From: Andrew Wood
Sent: 27 February 2020 15:54
To: Planning Scanning
Subject: LU/341/19/PL Additional Supporting Information

I am getting in touch with regards to the application for 37/43 Beach Crescent - ref LU/341/19/PL.

Proposed South Elevation NTS

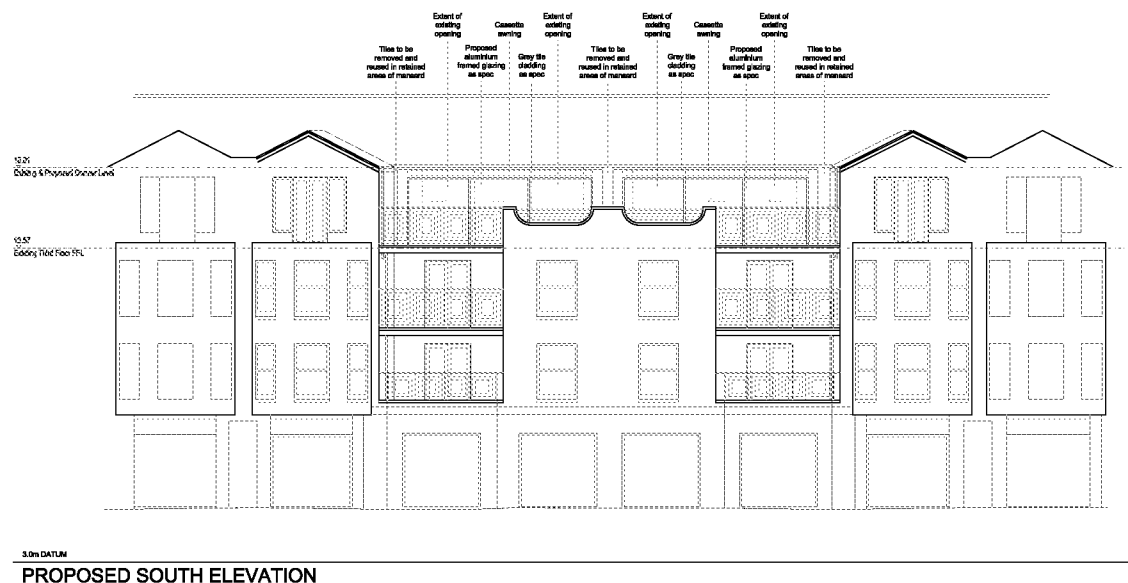
Notwithstanding the email below I have listened to the objections from neighbouring properties and am now of the view that any formation of sliding doors at second floor level will have an unacceptable impact on the character and appearance of the building.

The issue is that the design of the block and Beach Crescent is uniform and the proposal would break up the uniformity with an adverse impact on the character and appearance. It would not visually integrate with the block.

1. No objection to the merging of the two flats
2. Objection and grounds for refusal to the external alterations merging the two sets of dormers into single sliding doors.
3. No objection to removing the dividing balcony wall between the two flats.

I would however be prepared to accept the internal works only (plus the dividing balcony wall removal) to merge the two flats and considered that if this is accepted promptly I could process the application without the need for further re-advertisement and would hope to get a decision out by February 28th 2020.

Can you indicate if you wish to continue with the application for the merging of the two flats and the removal of the balcony dividing wall and provide an amended plan to that end ?
